**LONDON LUTON AIRPORT EXPANSION DEVELOPMENT CONSENT ORDER  
APPLICATION**

**ISSUE SPECIFIC HEARING 6 DEALING WITH MATTERS RELATING TO  
BIODIVERSITY, WATER, LAND-USE, LANDSCAPE AND VISUAL, DESIGN AND  
HERITAGE.**

**POST HEARING SUBMISSION FOR CENTRAL BEDFORDSHIRE COUNCIL**

Representative Viewpoint 17 : Luton Hoo House

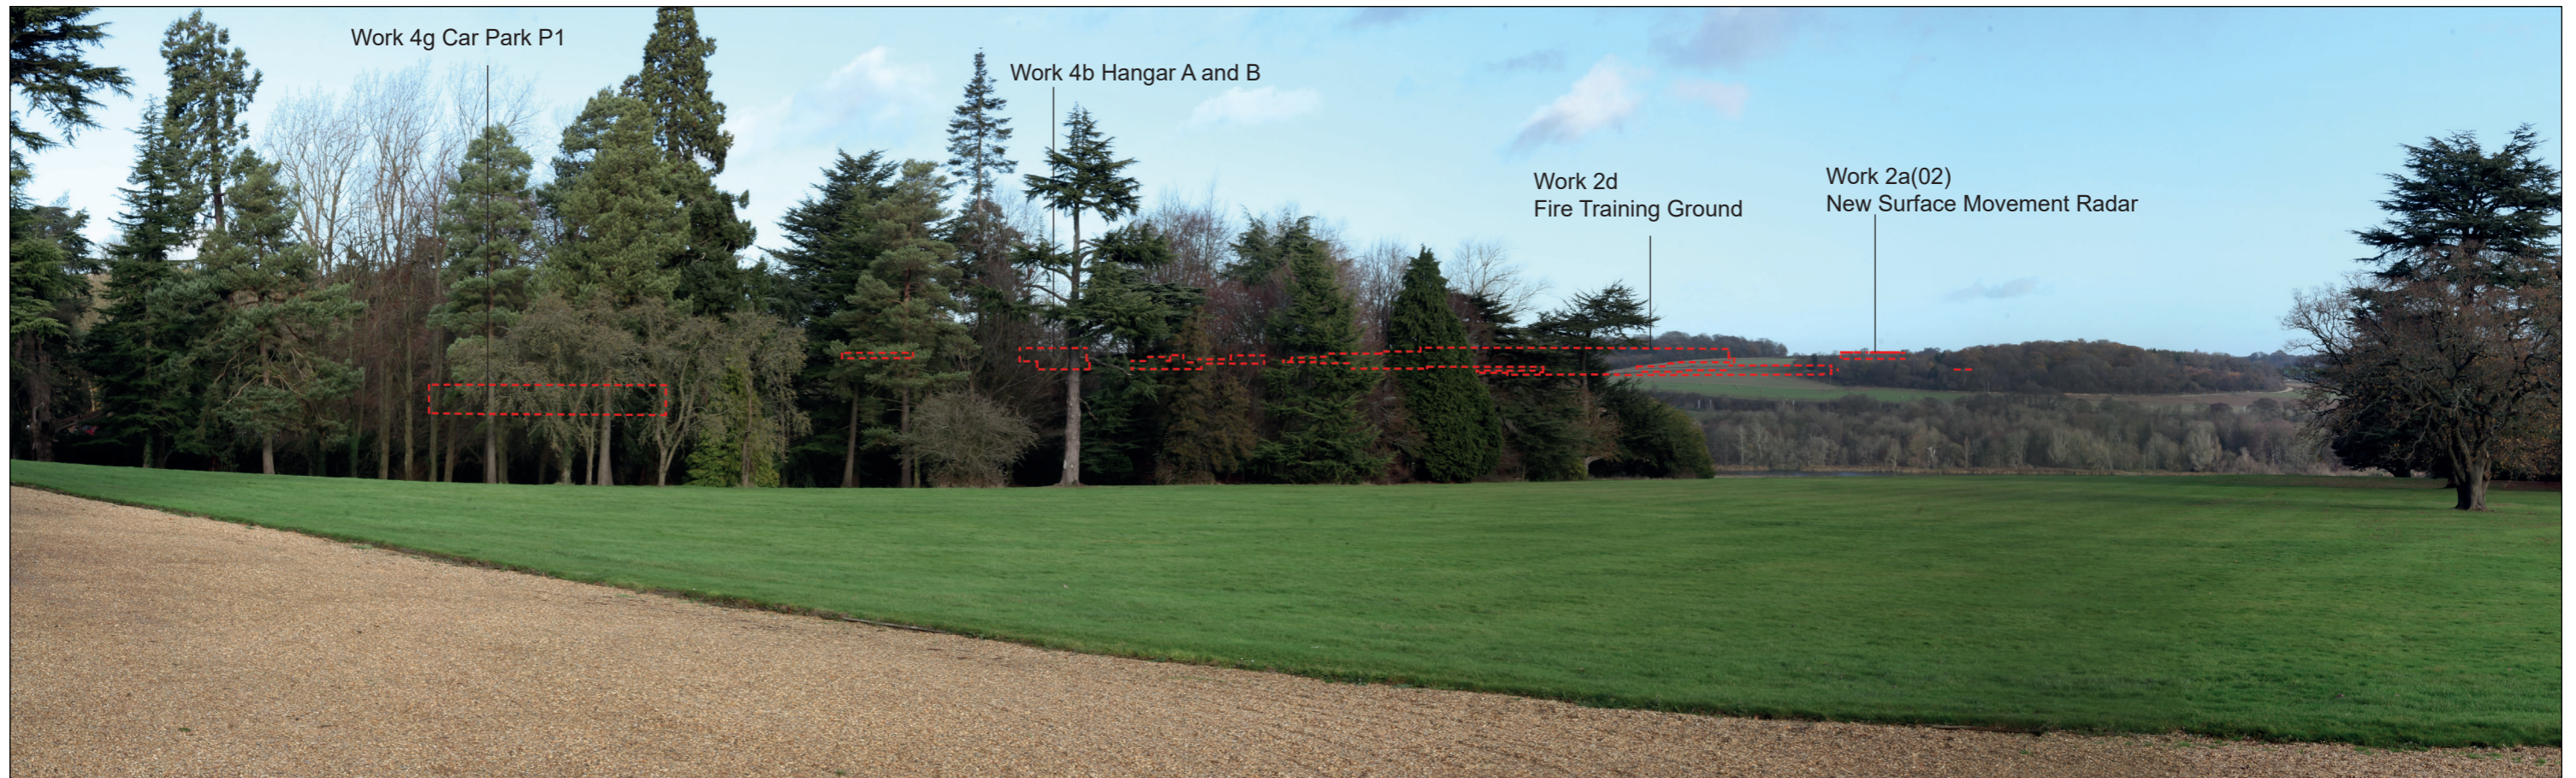
7. Cultural Heritage	
<p>Assessment of effects and harm on designated heritage assets with a focus on the assets where disagreement exists between parties</p>	<p>The Applicant displayed viewpoints 17, 17a, 18 and 19 from Appendix 14.7 of the ES (AS-141 and AS-142).</p> <p>In response to a query from the ExA asking CBC to talk through concerns regarding lack of clarity in the visuals from Luton Hoo, the Council's Conservation Officer confirmed that clarity is sought in respect to the use of wirelines and blocks in the visuals, along with clarity with annotations to show the landscape features and the elements of the proposed development. This information has been provided by the Applicant and assist in assessing the proposal in terms of the wider landscape.</p> <p>The Council's Conservation Officer provided a detailed summary of Viewpoint 17A from the upper floors of Luton Hoo mansion, explaining that the historic landscape goes beyond the boundaries of the Registered Park and Garden. The effectiveness of mitigation to screen the development was discussed and needs to be carefully considered so that it does not affect the historic openness. For example, the use of screen planting would compromise the elements of openness that are part of the historic landscape.</p> <p>The EXA asked CBC to confirm if screen planting to the front of the FTG would be an unsuitable form of mitigation because it would not relate to the traditional form of the landscape. CBC's Conservation Officer confirmed that this would compromise the historic openness and counterpoised with the plantations of George Wood and Bush Pasture. CBC confirmed that potentially a lesser form of planting could maintain that sense of openness without compromising the landscape. This would need to be considered.</p> <p>The ExA sought clarification as to whether the information/assessment on the use of the Fire Training Ground was sufficient and whether the Cultural Heritage Management Plan provides suitable monitoring. In response, the CBC Officer confirmed that internal discussions between the Conservation Officer and Public Protection are still taking place. A meeting has taken place with the Applicant, who has advised that information is available in Chapter 7 of the ES relating to air quality. The Council's Conservation Officer added that the proximity of the fire training ground, its frequency of use and nature of its use causes concern in respect to the delicate brick fabric of Someries Castle. The CBC Conservation Officer highlighted that decay of the building has accelerated in the last 40 years and this provides an opportunity to understand whether this is related to the increased operational activity at the airport. Monitoring is welcomed, which would form part of the Cultural Heritage Management Plan, but it is unclear what mitigation could be used if the monitoring results show airborne pollutants are causing brick fabric decay. This is not documented in the Applicant's submission. Positive steps have been taken forward by the Applicant, but further work is required.</p>

Viewpoint No.	Details
5 Warren Drive (ref. AS-149)	Car Park P1 incorrectly shown
18 The Luton Drive (ref. AS-141)	Proposed car park P1 to be shown as 'rendered' block form.
19 Luton Hoo Parkland (ref. AS-141)	Several hatched boxes on the visual have no annotation.
20 Footpath (Hyde 5a) (ref. AS-141)	Block is acceptable. Request a visual to show the hedgerow mitigation planting.
23 Someries Castle 1 (AS-141)	Can be accepted as wirelines as this relates to work 2b IRVR.
24 Someries Castle 2 (AS-141)	Hatched box does not have any annotations.
24 Someries Castle 2 (showing Someries Farmhouse) (AS-141)	FTG should be shown in block.
25 Someries Castle 3 (AS-141)	There are missing annotations.
25 Someries Castle 3 (AS-141)	FTG should be shown in block.
44 Stopsley Wood, Luton Hoo (Assessment Viewpoint ref. AS-094)	Incorrectly annotated – this is Stockings Wood
